Dean Moor Solar Farm

Applicant Response to Cumberland Council's Response to ExA's First Written Questions [REP2-059]

30 September 2025
Prepared by: Broadfield
PINS Ref: EN010155
Document Ref: D3.3
Deadline: 3
Revision: 1

Environmental Statement: Chapter 2 – Figure 2.1 Cumulative Schemes within 10km of the Order Limits

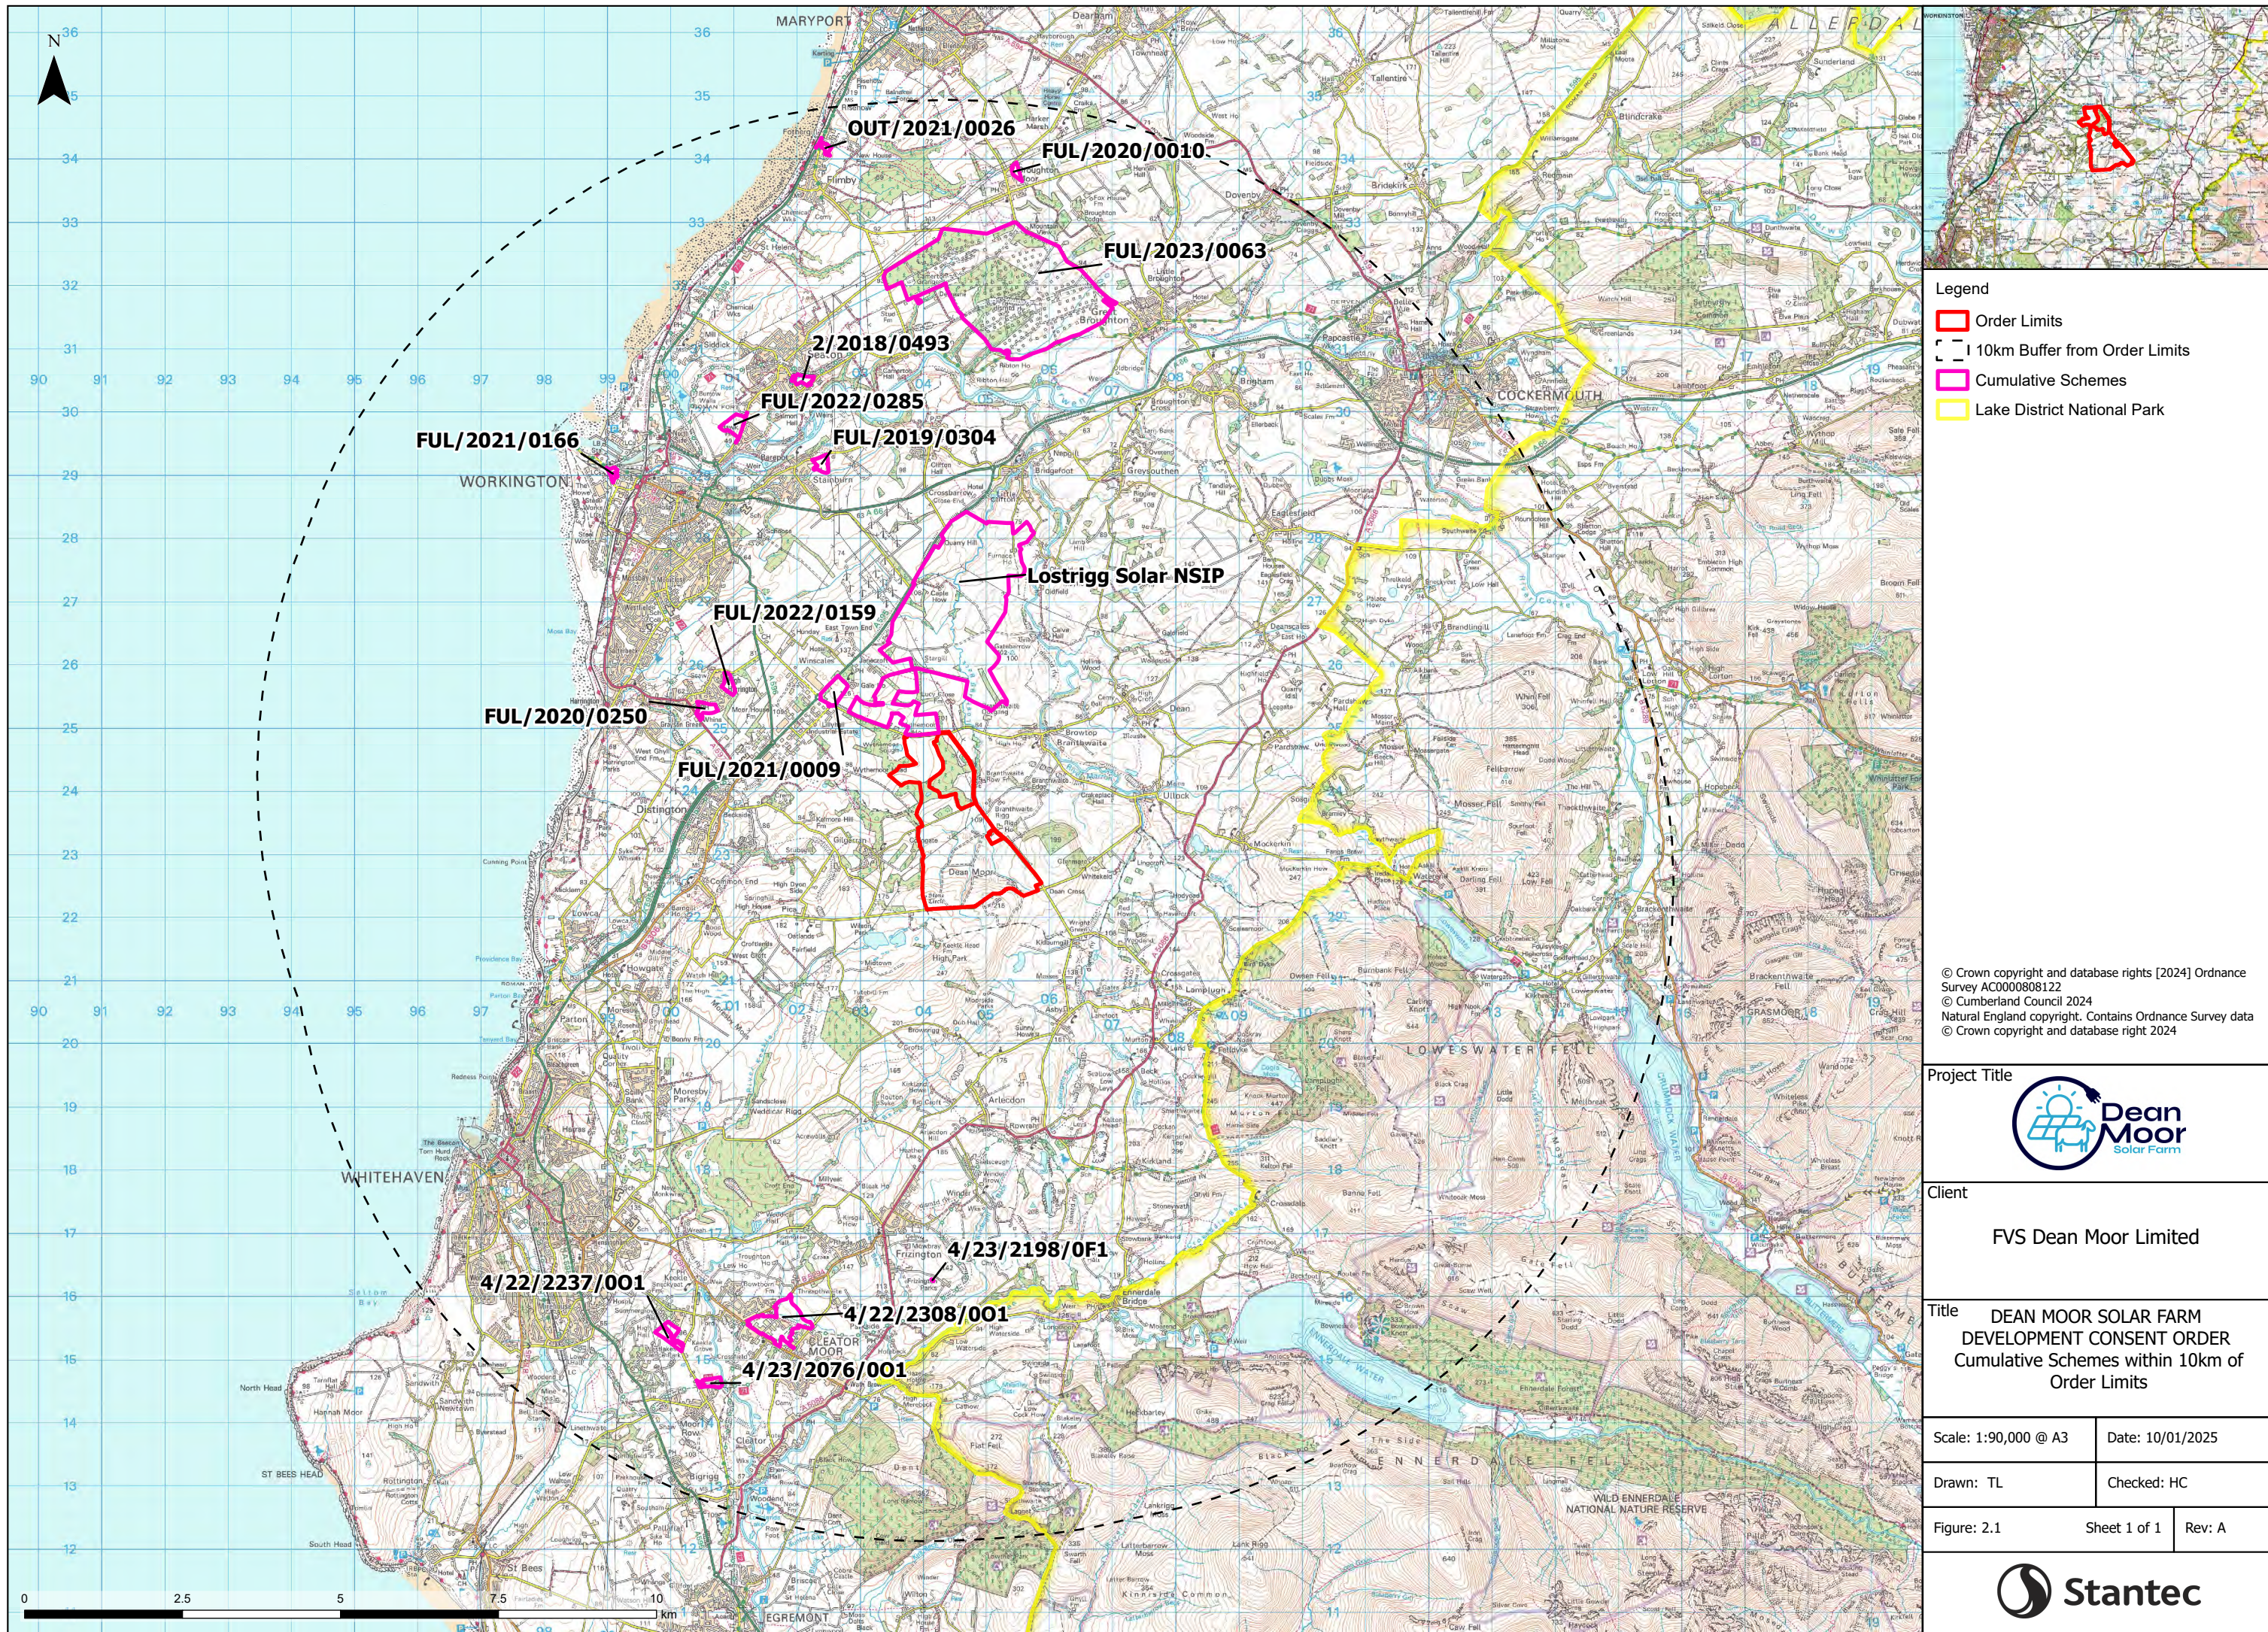
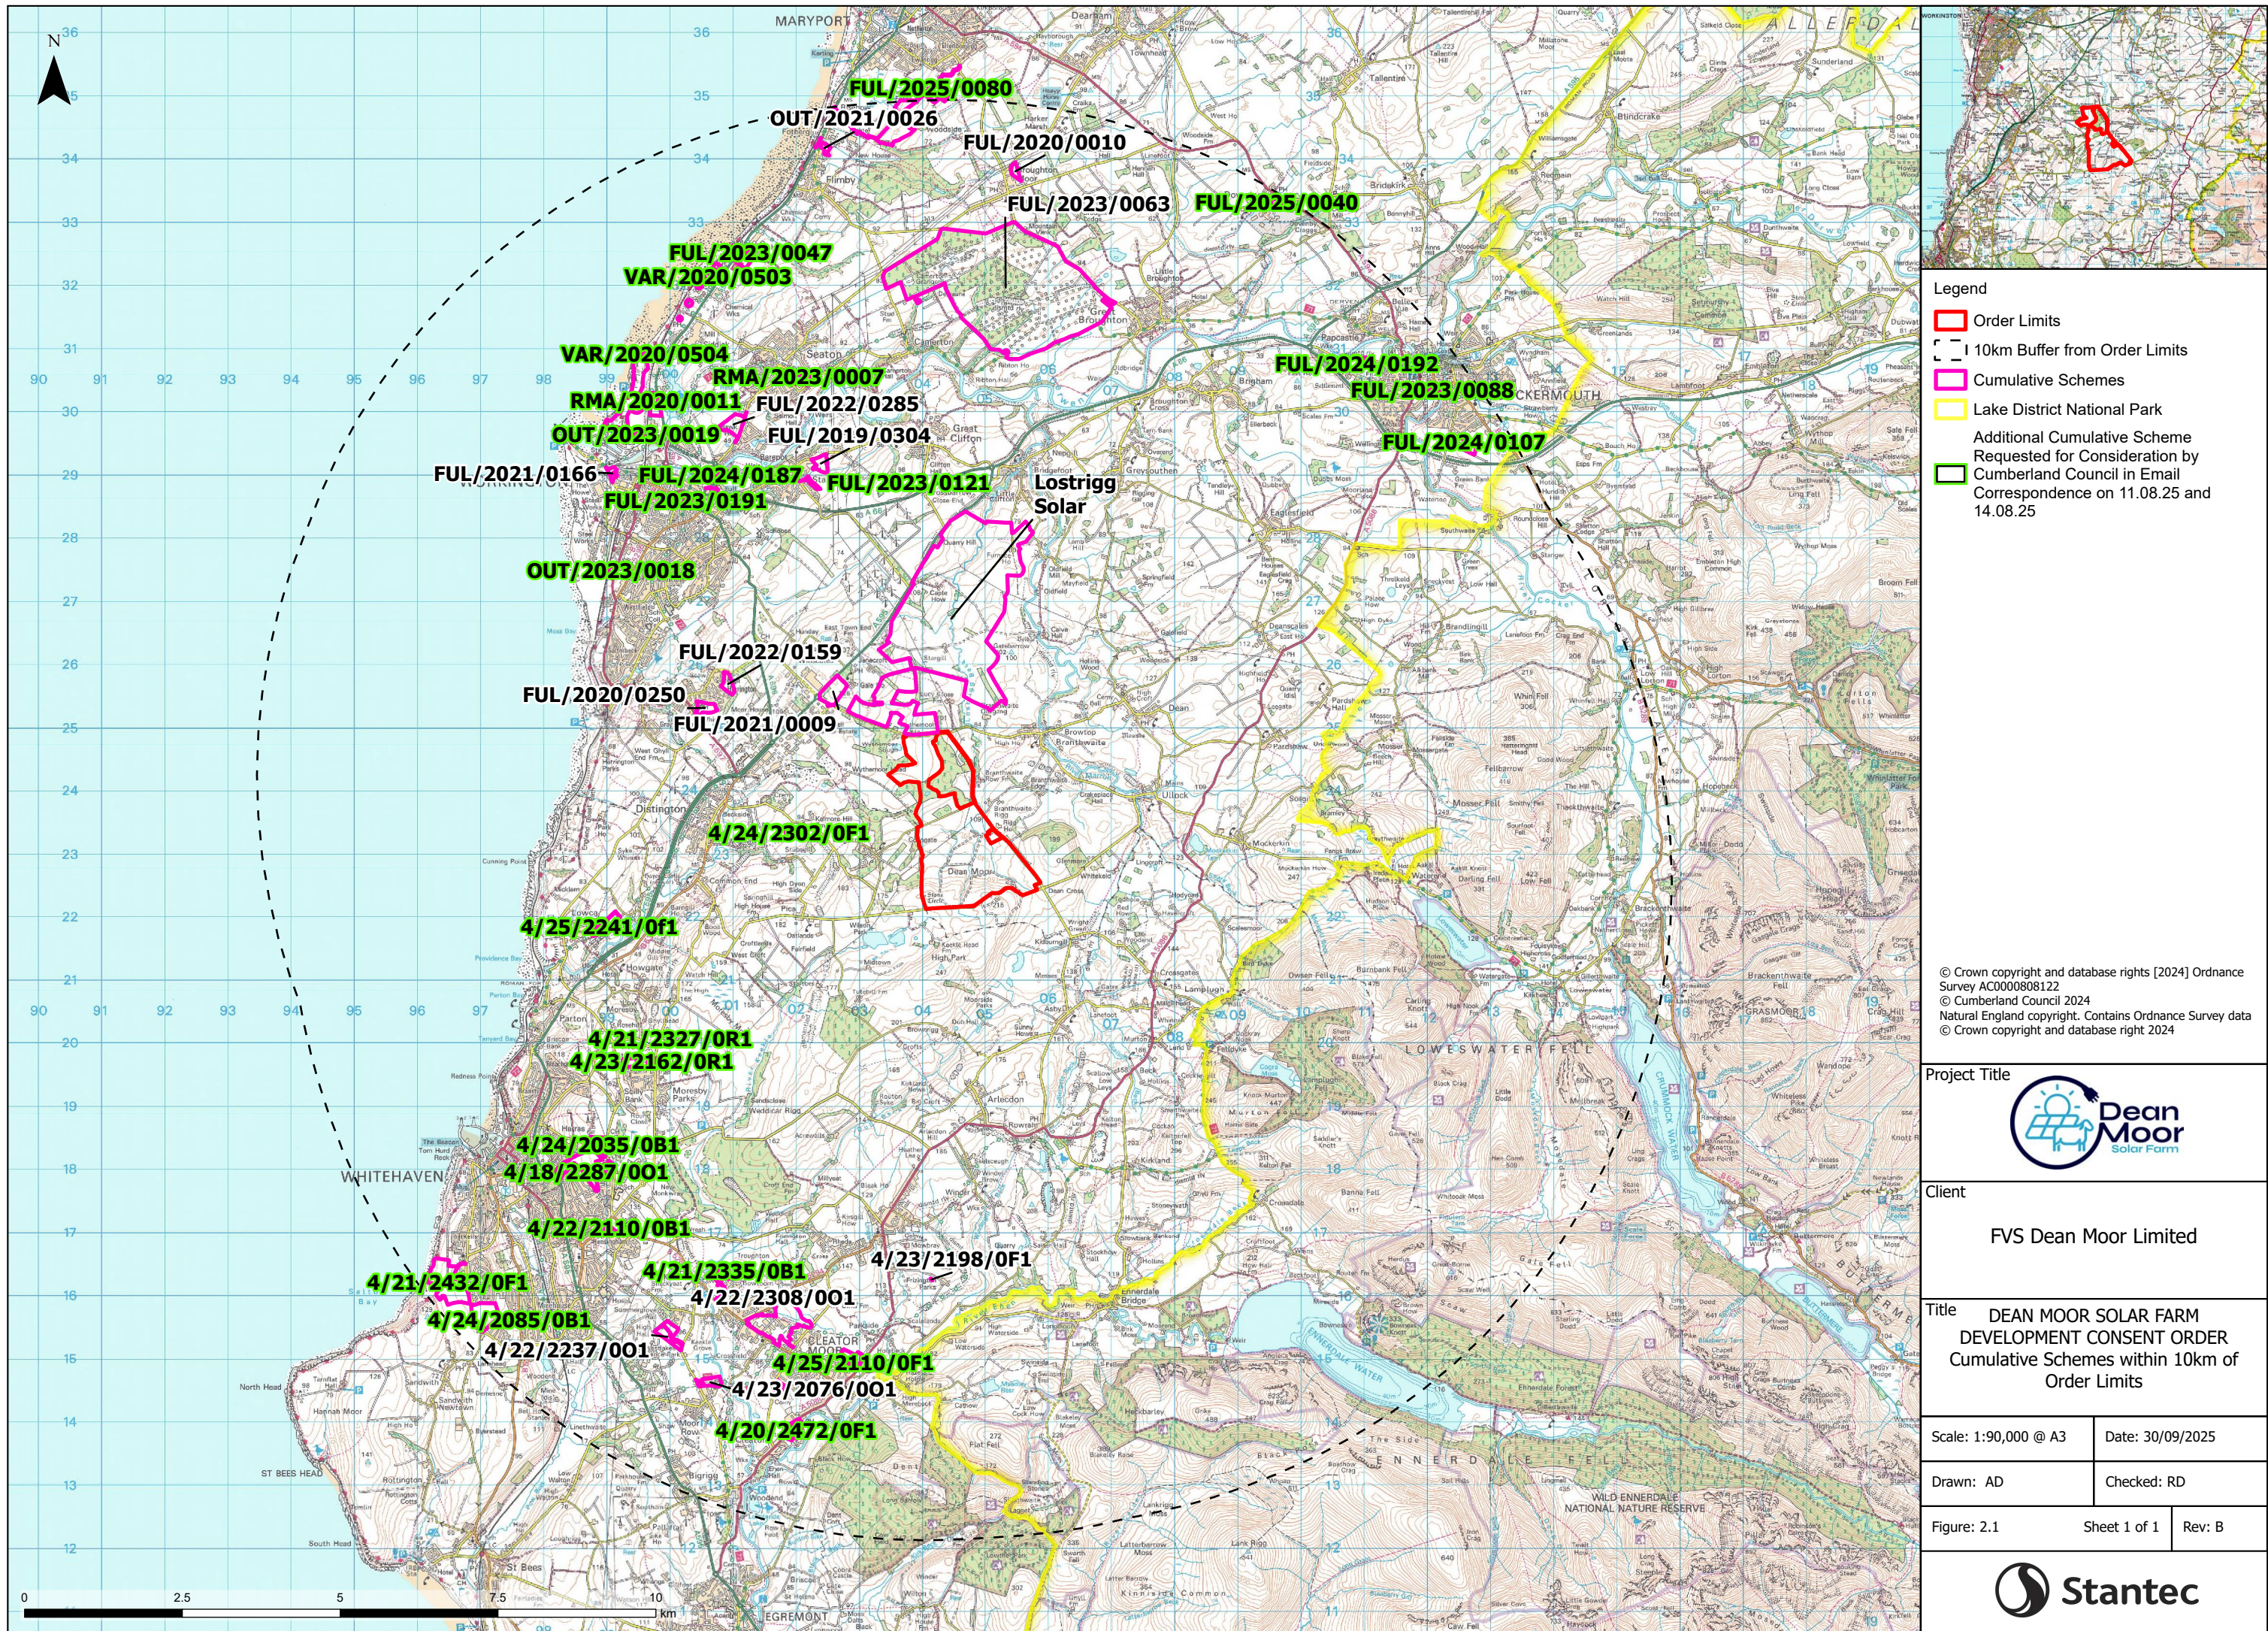
Q4.0.7: <i>ES chapter 2 – please confirm that the list of cumulative schemes set out in table 2.6 is complete and should be used by the ExA to inform the cumulative assessment, otherwise please provide an alternative list. This was also requested by the ExA in relation to a Statement of Common Ground (SoCG) in the rule 6 letter.</i>	<p><i>The Council provided additional details of potential sites for consideration under cumulative assessment on 14th August 2025. The Applicant is currently considering these additional sites. It is not anticipated that any of them will alter the assessment of cumulative effects in the ES to any great extent.</i></p>	<p>The Applicant has undertaken a proportionate and robust cumulative assessment of these schemes for technical disciplines.</p> <p>A cumulative environmental effects technical note which considers these schemes is included at Appendix A of the 'Applicant Response to the Local Impact Report' [D3.7].</p> <p>The Council has confirmed that the overall conclusion of this assessment aligns with the Council's expectations that the additional schemes do not alter the assessment of likely significant cumulative environmental effects in the ES. This Council's agreement on this matter is recorded in the dSoCG submitted at D3 [D3.14].</p>
